Western Sydney Parklands Trust

RE: M12 Motorway (SSI-9364)

Attachment A – Summary of impacts and requested conditions of consent

Figure 08
Areas Impacted by M12

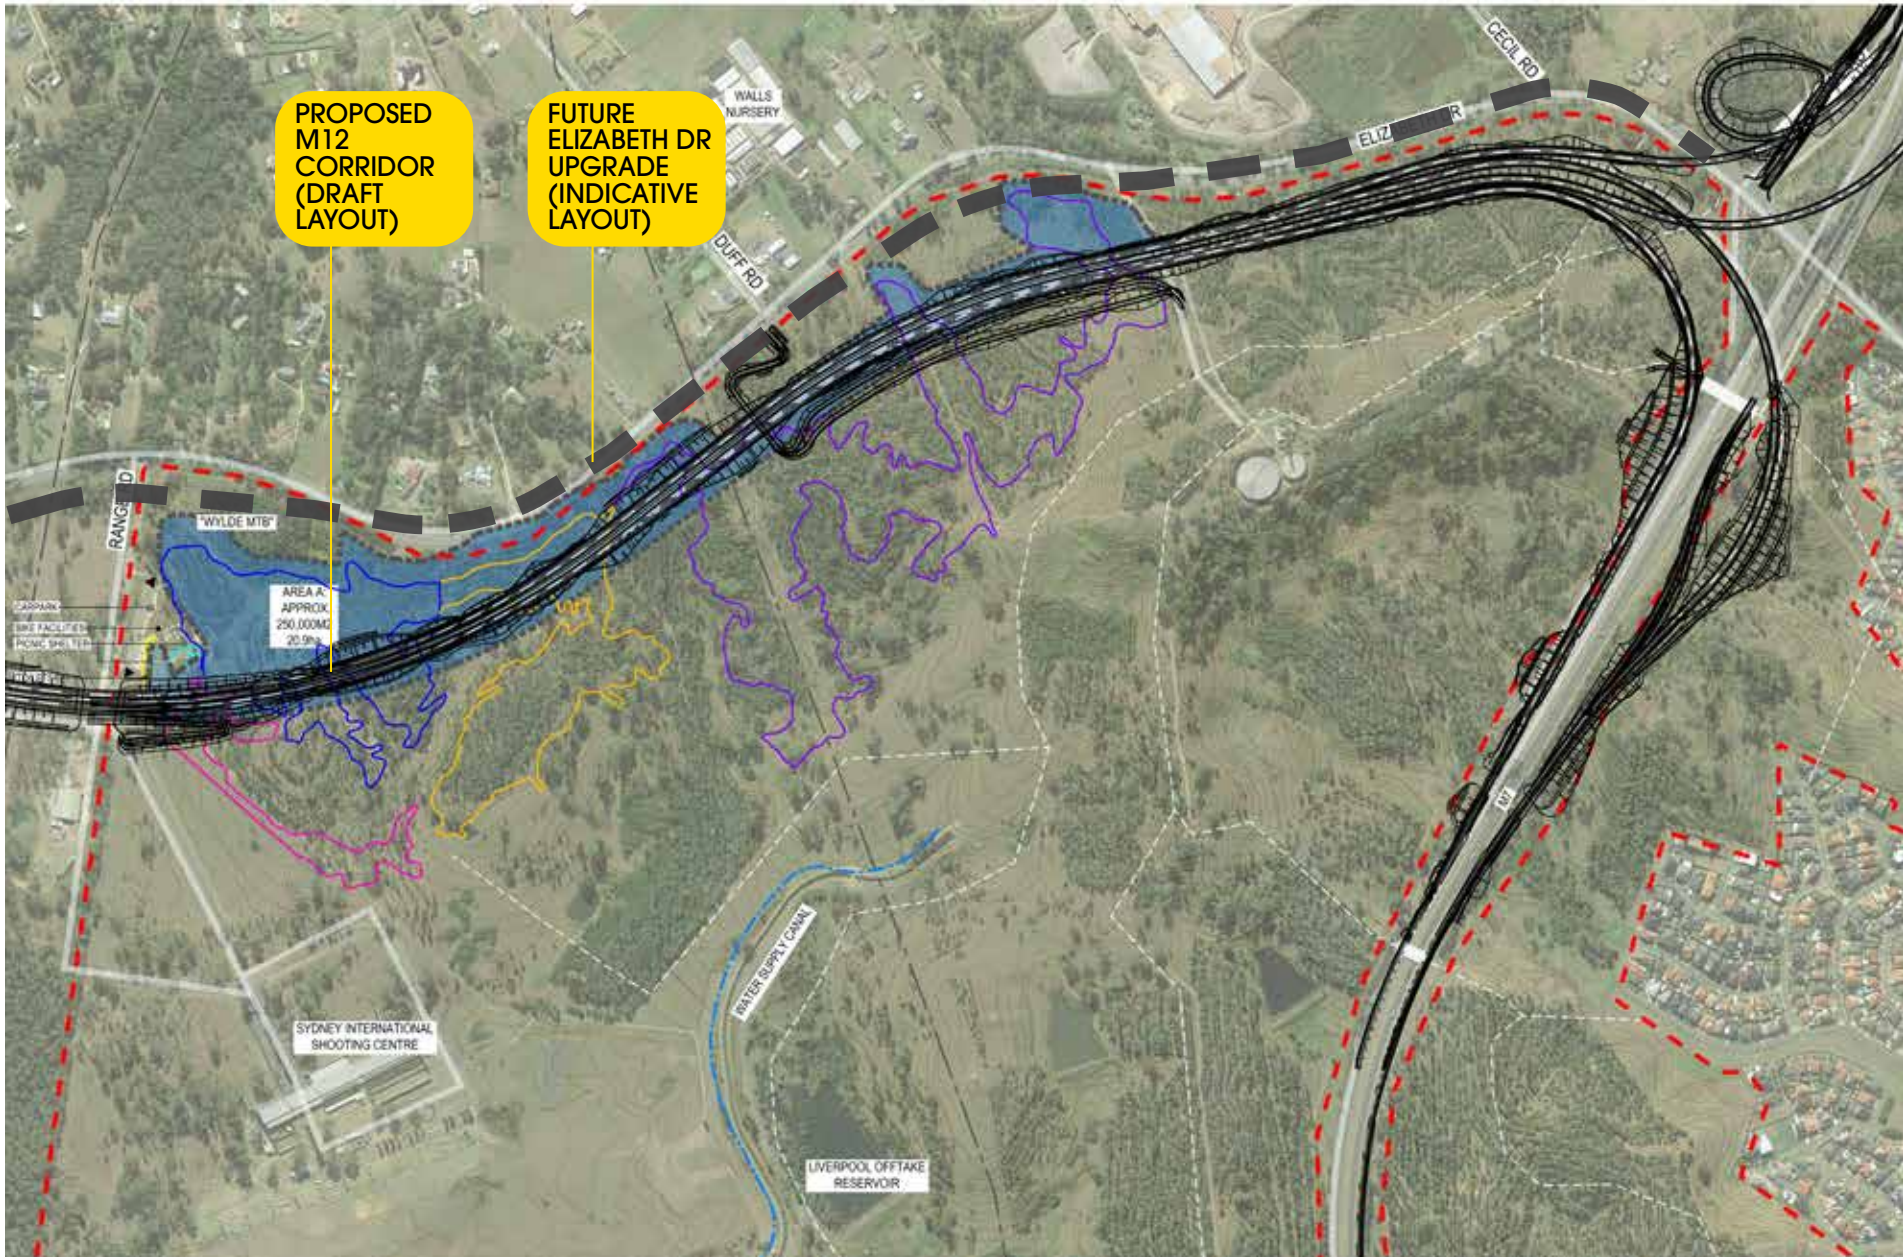
- The Wylde Mountain Bike Trail would be directly impacted by the siting of the project corridor, including the jump run, pump track, kids loop, sections of the three-kilometre, six-kilometre and 12-kilometre trails and associated facilities, including shelters.
- WSPT will redesign and relocate the trail with full financial support from Roads and Maritime. This will include a new road to access the facility from Range Road. Redesign and relocation of the Wylde Mountain Bike Trail will occur before the start of construction allowing access to the trails and other facilities to be maintained during construction and helping to reduce disruptions for users.
- WSPT supports this and design work has already commenced on the relocation of Wylde. The Trust looks forward to continuing to work with RMS on relocating this important community facility.

Figure 10
Duff Road Entry Parklands Connection

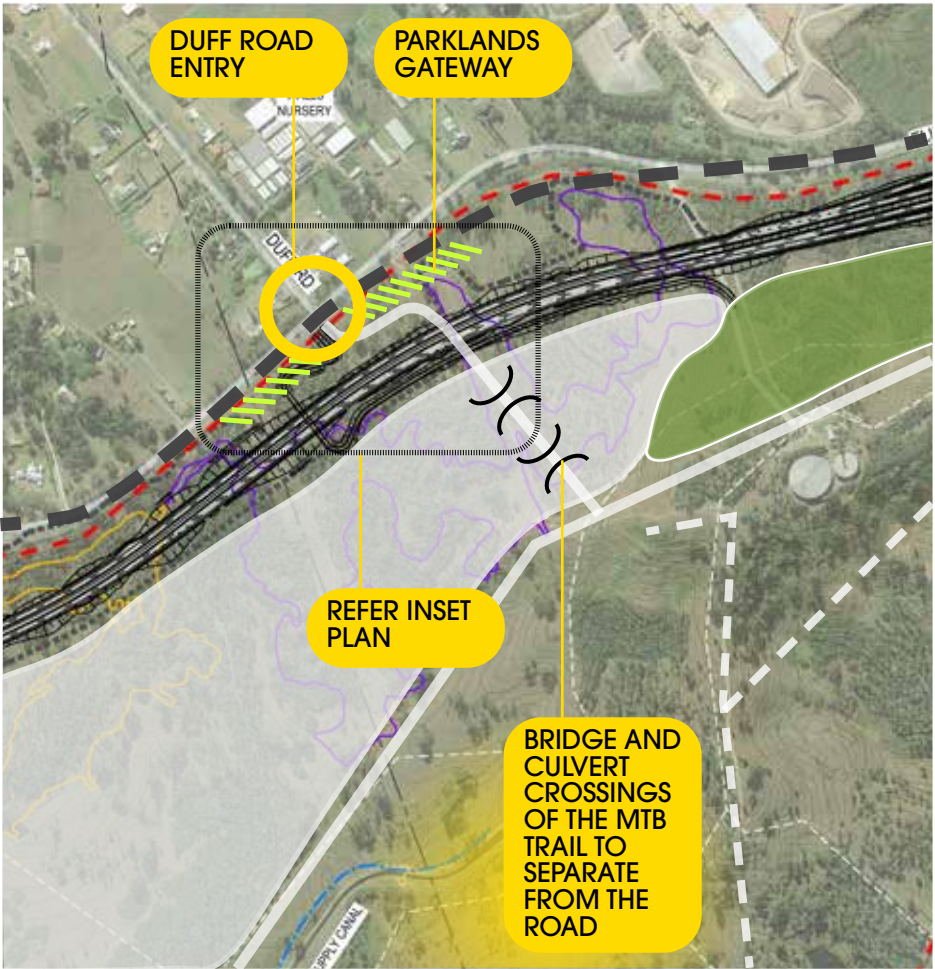
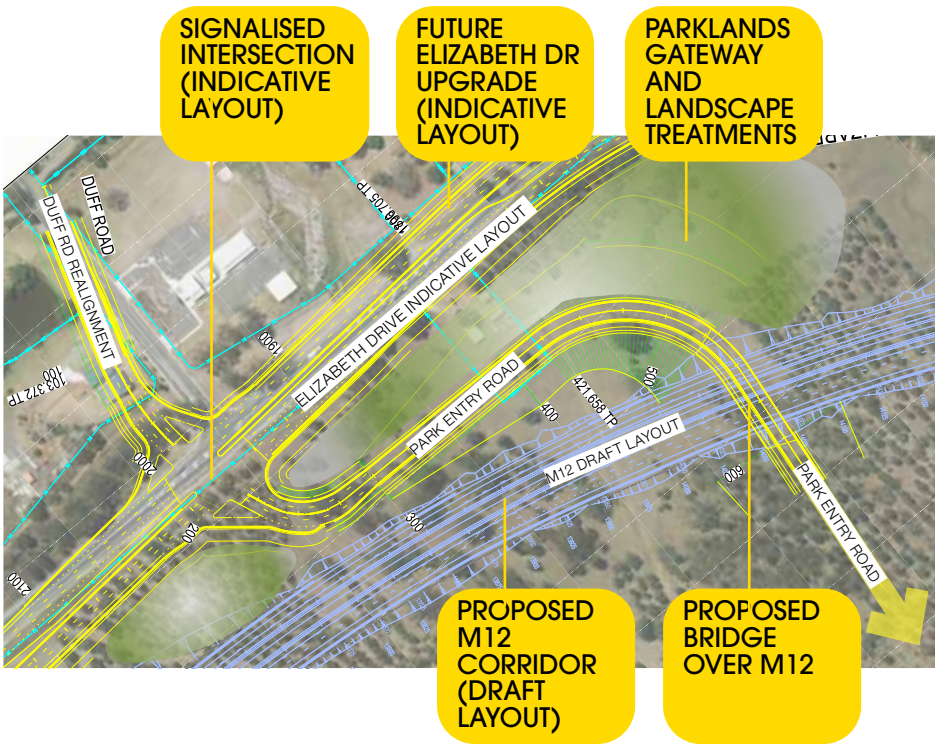
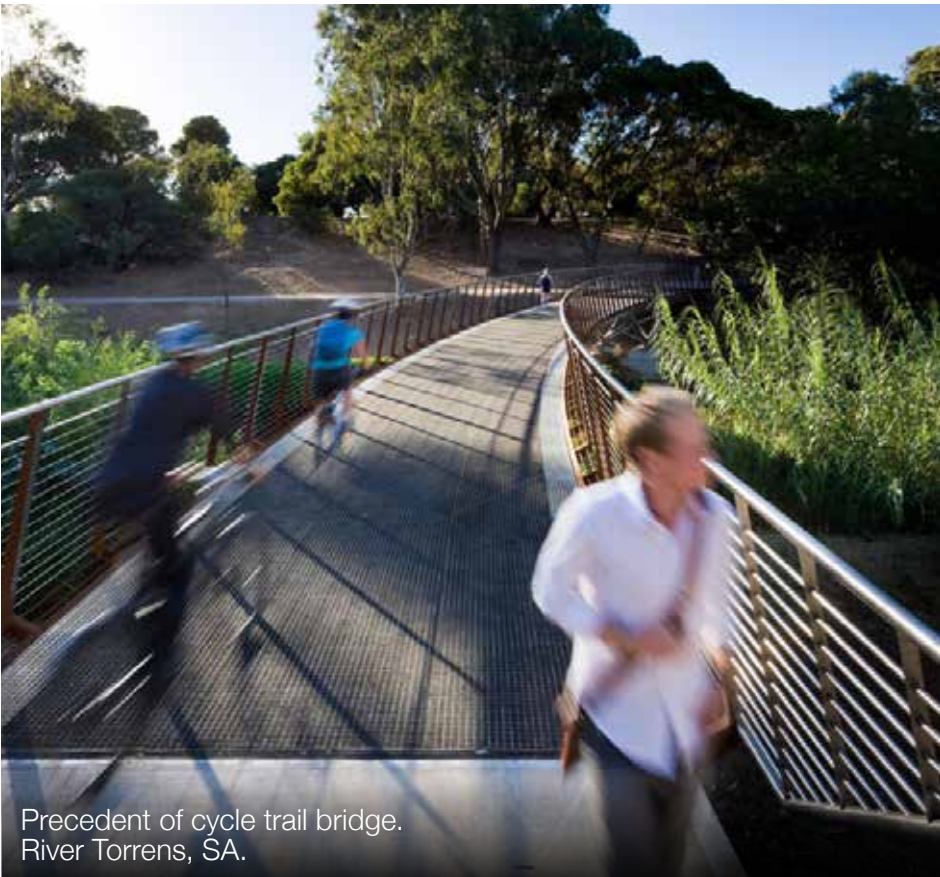
- The EIS refers to this access as a utilities access road bridge – BR11.
- The proposed Duff Road entry off Elizabeth Drive will be a future major entry point for visitors to the Parklands. As such, it is essential that this intersection be signalised (which is assumed in traffic modelling for the project), and that appropriate pedestrian, cyclist and vehicle capacity be provided when building the access bridge. It is understood that this is being developed in coordination with the proposed urban area north of Elizabeth Drive.

- This bridge should be designed as a major entry into the Parklands, not simply as a utilities access road with basic engineering design and no urban design overlay.

- WSPT continues to reiterate that the second road access at Duff Road into the Parklands needs to allow for the capacity for the future traffic demand of the Parklands' recreation and tourism land-uses such as hotel, camping and cabins, lookout, and recreational facilities and infrastructure of Cecil Hills area of Southern Parklands. The current dog-leg arrangement of only a two-lane road for accessing this precinct and future tourism and recreation hubs is a safety concern due to 'blind corners' and poor arrival experience for all future visitors to the Parklands.

Figure 12
Range Road Entry Parklands Connection

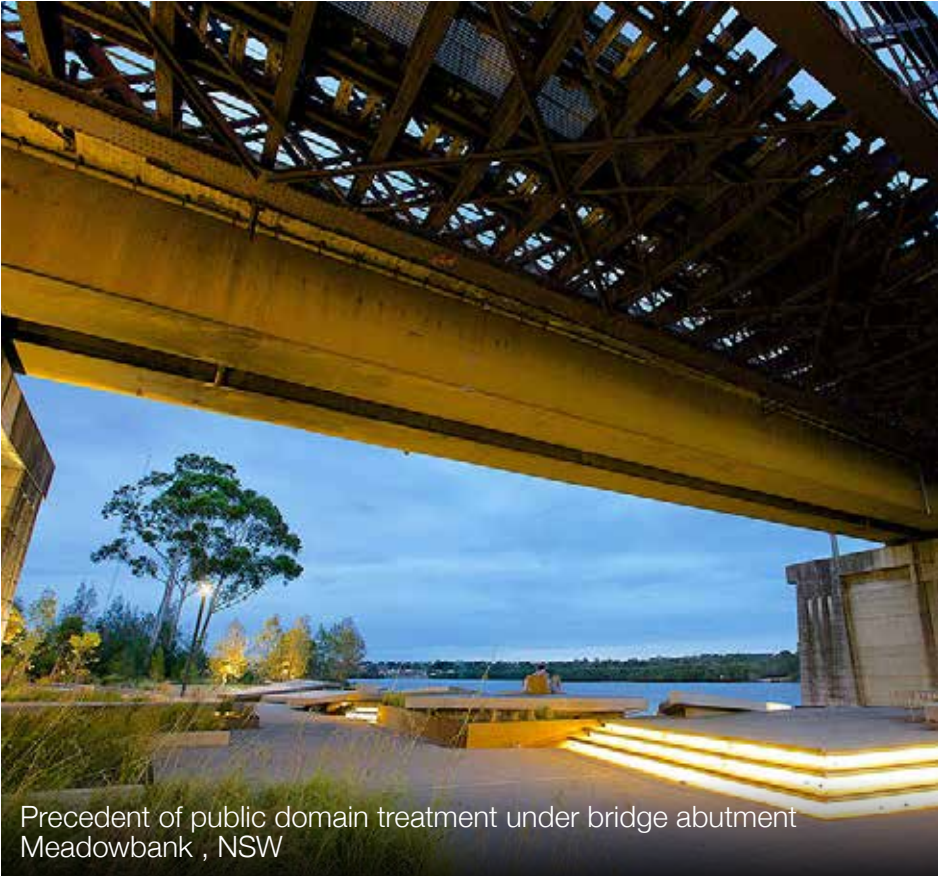
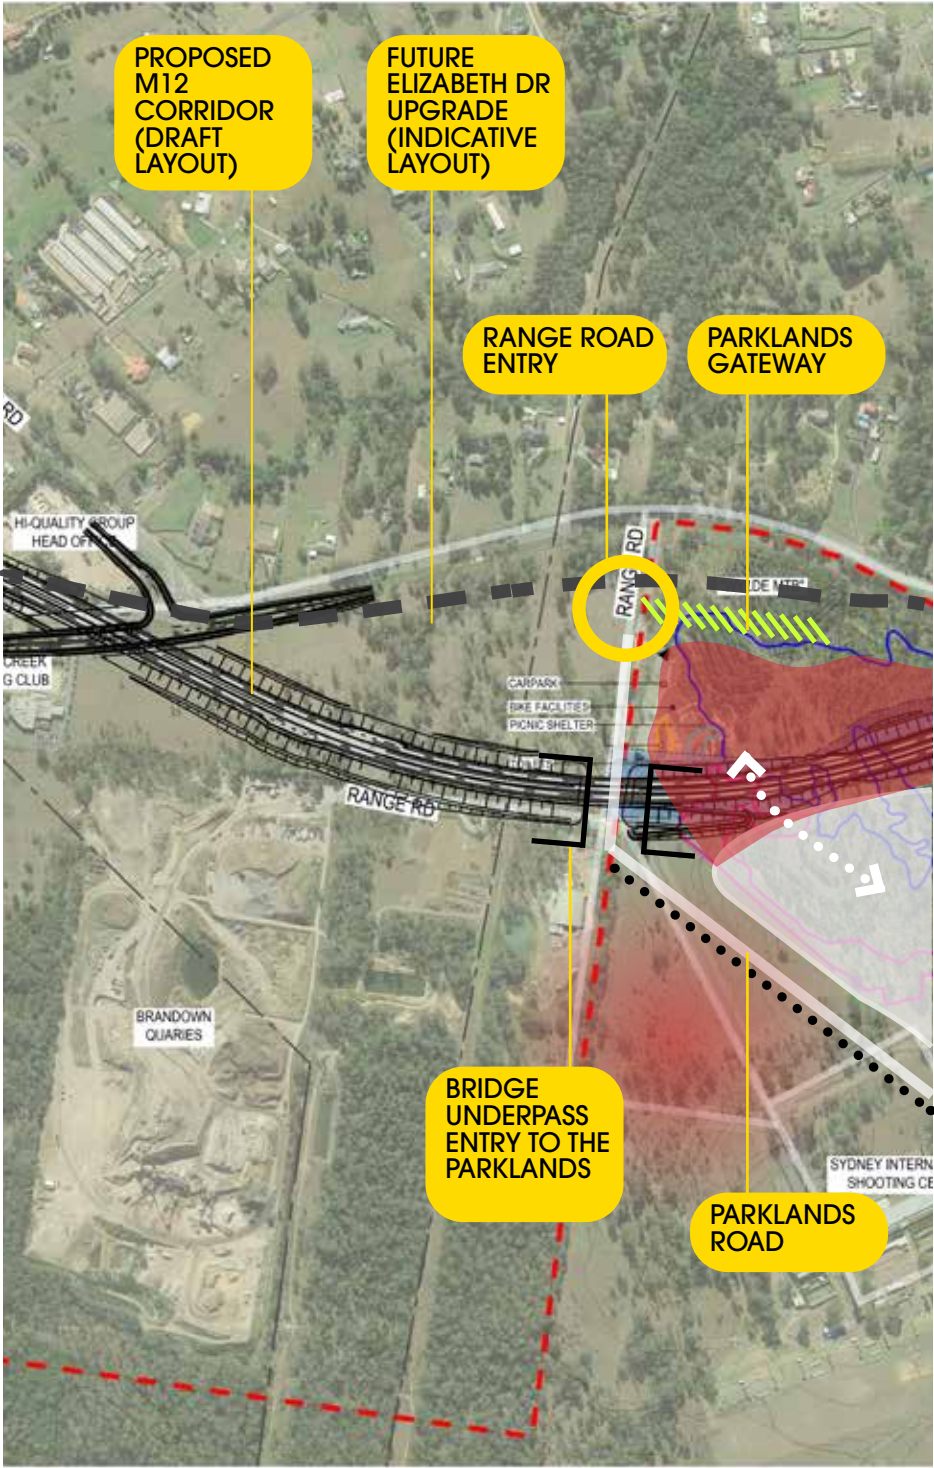
- Primary access to the Cecil Hills area of the Southern Parklands will be off the intersection of Elizabeth Drive and Range Road. WSPT continues to reiterate the

requirement that this intersection should be signalised as part of the Elizabeth Road upgrade. The Transport and Traffic Report for the project does not appear to address the Elizabeth Drive / Range Road intersection.

- The Range Road bridge / underpass design is not appropriate as the future major entry to the Southern Parklands. The vehicle entry points to the Parklands should be of a high-quality design that is aesthetic, functional and modern whilst respecting the existing landscape. Range Road bridge and underpass needs to be wider, more open and create a visual sense of arrival to the Parklands and the future land-uses of the Adventure Sports and Tourism Precincts and support active travel links.

- This bridge / underpass should also consider future traffic requirements to ensure that if a widening of Range Road is required in the future that there is adequate width to allow for this widening of Range Road without impact to the arrival experience and active travel paths.

Figure 13
Northern Parklands Cycleway Connections

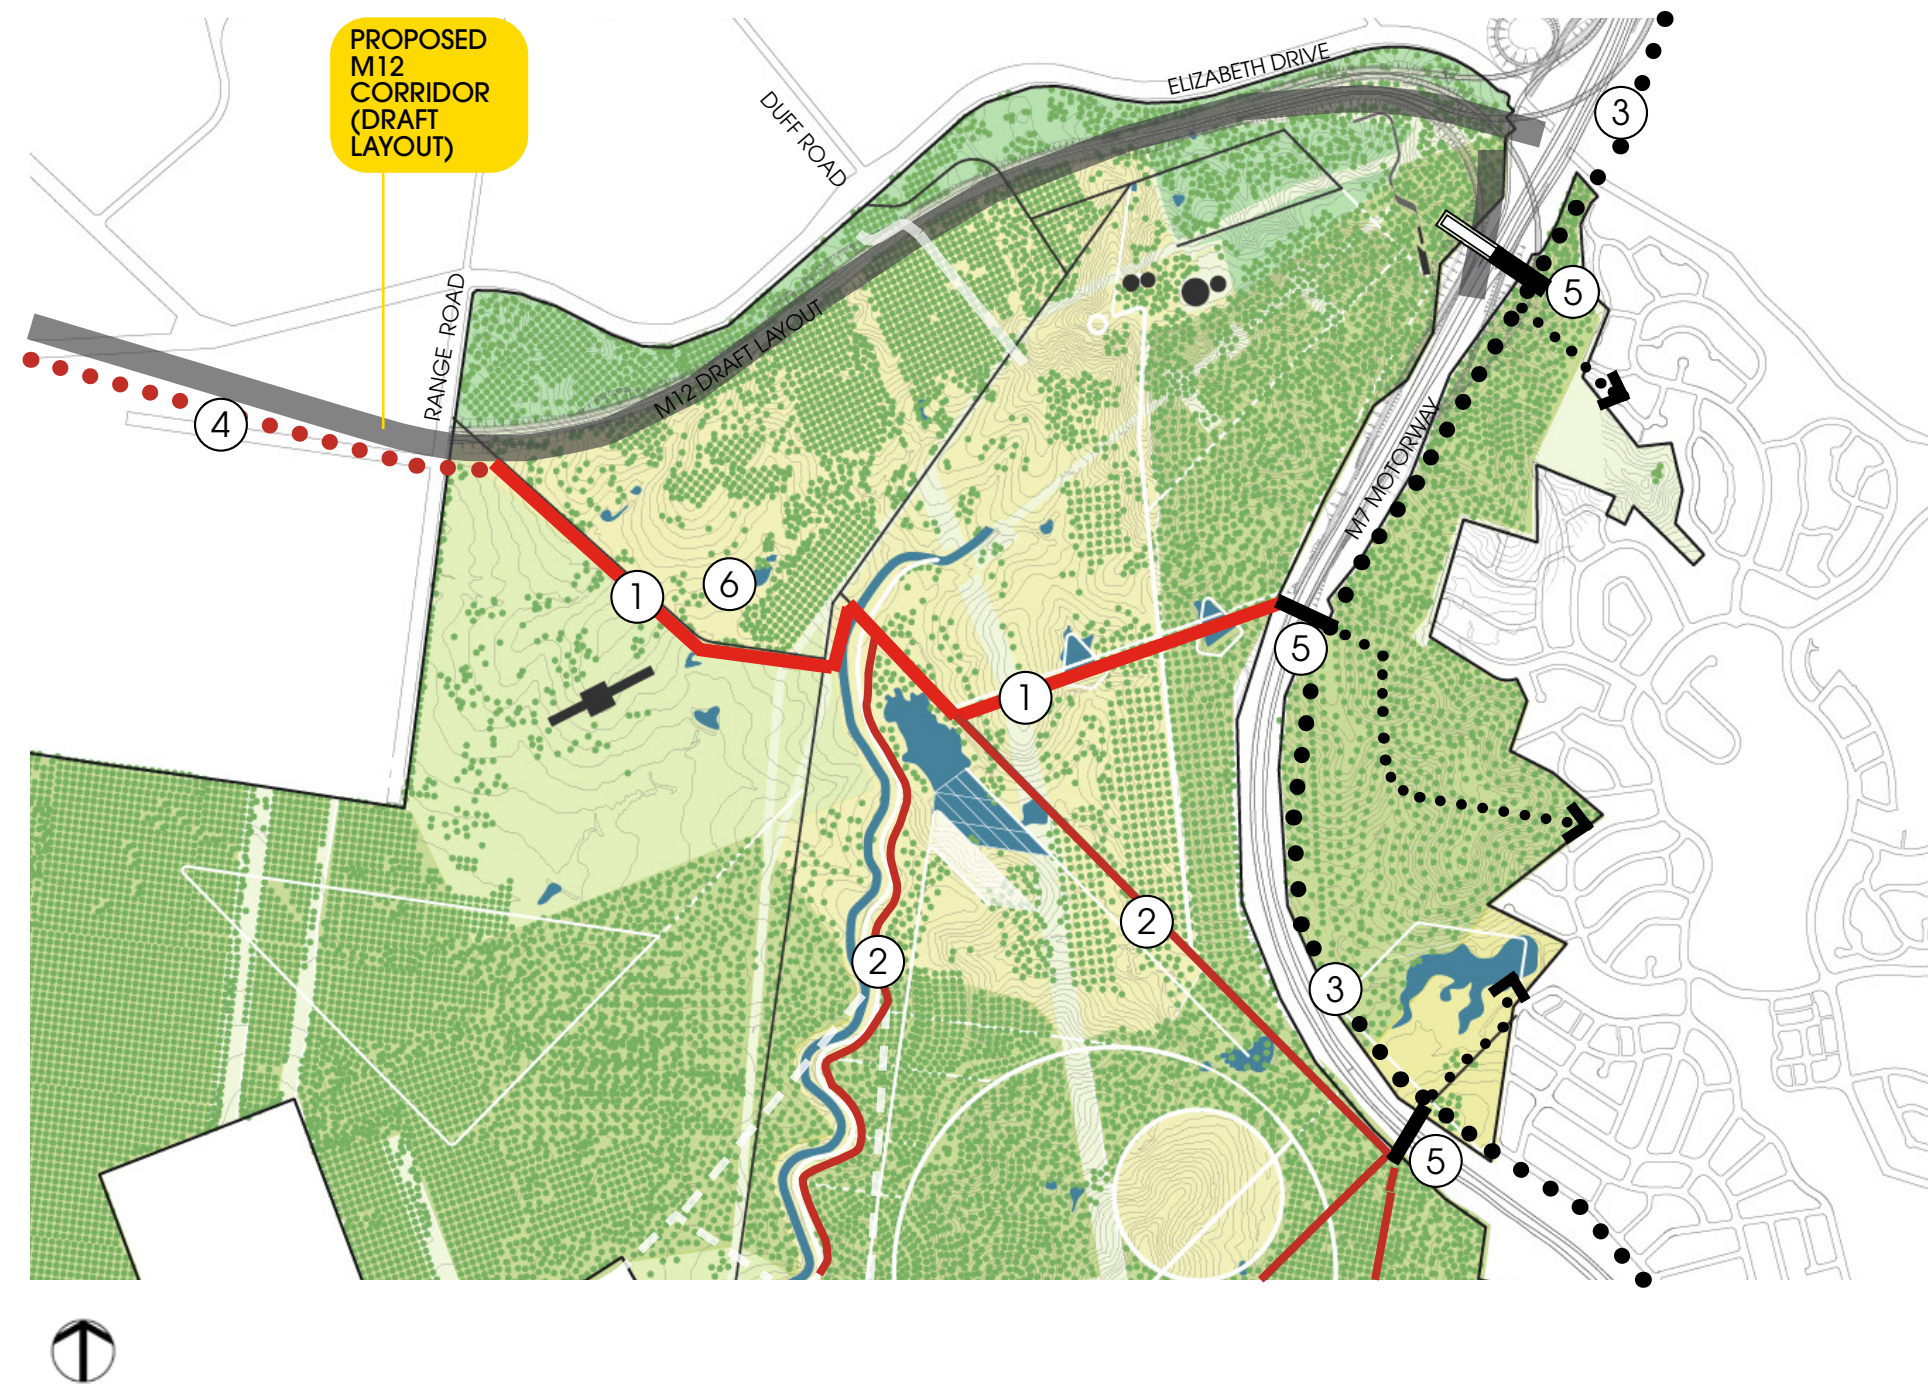
- The EIS states that the section of the shared user path through the Western Sydney Parklands, linking the M12 to the M7 cycleways, does not form part of the M12 Motorway project. If this proceeds, it could be implemented by the WSPT with full financial support from RMS. This link, known as the Mirror Dam Cycleway will allow cyclists to experience the changing landscape through shaded treed vistas, slices through hilly terrain and across waters of the twin dams and Liverpool Dam. Some design work has already been undertaken for this link to the Trusts design specification.

WSPT considers that a shared user path linking the M12 cycleway to the M7 cycleway should be part of the M12 project. WSPT can implement this to the Trusts widths and design specifications, with full financial support from RMS.
